WEST SUSSEX COUNTY COUNCIL CONSULTATION

TO:	Arun District Council FAO: Michael Eastham
FROM:	Stephen Gee WSCC - Highways Authority
DATE:	22 July 2021
LOCATION:	Land East of Tye Lane Walberton BN18 0LU
SUBJECT:	WA/63/21/PL Proposed alternative vehicular accesses off Tye Lane and emergency access off Avisford Park Road, along with minor highway works following WA/95/18/RES (resubmission following WA/93/20/PL). This site is CIL Zone 2 (Zero Rated) as other development.
DATE OF SITE VISIT:	n/a
RECOMMENDATION:	Advice / More Information
S106 CONTRIBUTION TOTAL:	n/a

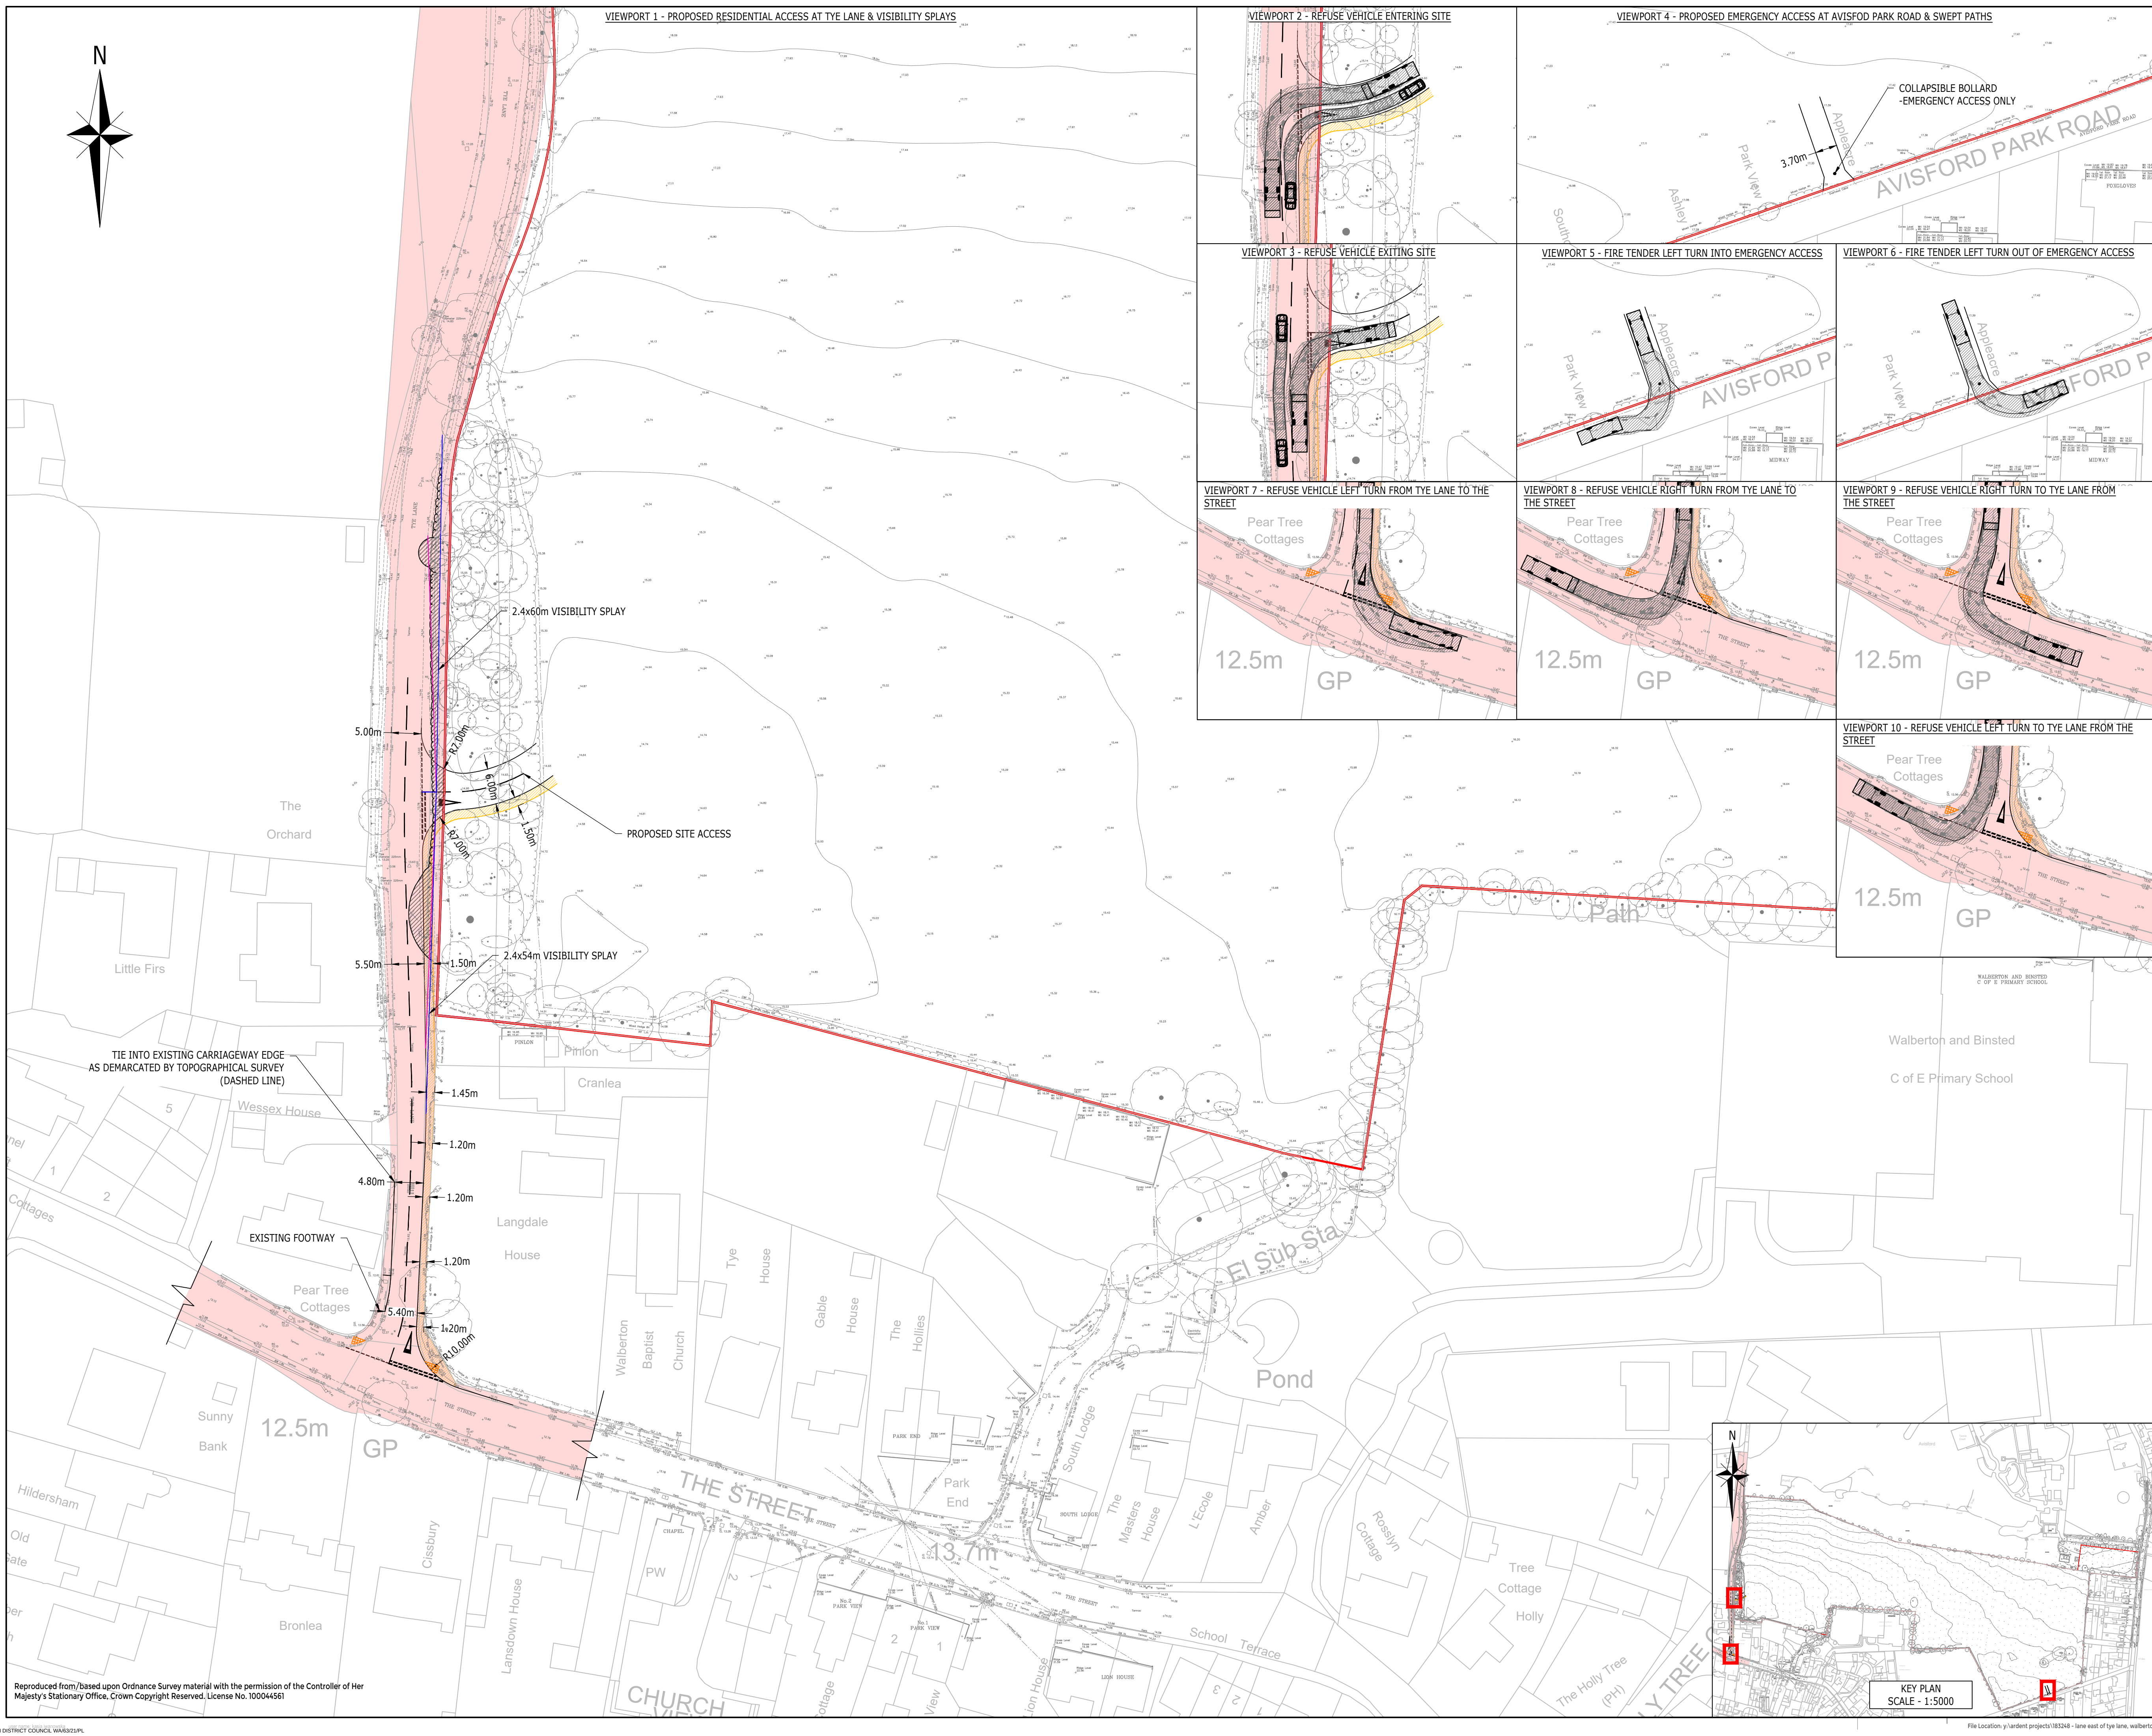
An additional 52 and 33 two way movements in the AM and PM peaks would utilise the A27/Tye Lane junction and as such an improvement scheme is set out on drawing ref ACE Drawing 183248-005 compromising improvements to the junction to conform to design parameters included with CD123.

Additionally the Transport Assessment Addendum states that a restriction on U-turn movements at the junction of the A27/Yapton Lane could also be provided.

It is understood a stage 1 road safety audit is to be undertaken on the A27/Tye Lane proposals. Additional comments maybe provided on sight of the audit if any of the issues identified are on the WSCC highway. Further details on the proposed A27/Yapton Lane U turn restrictions are also requested.
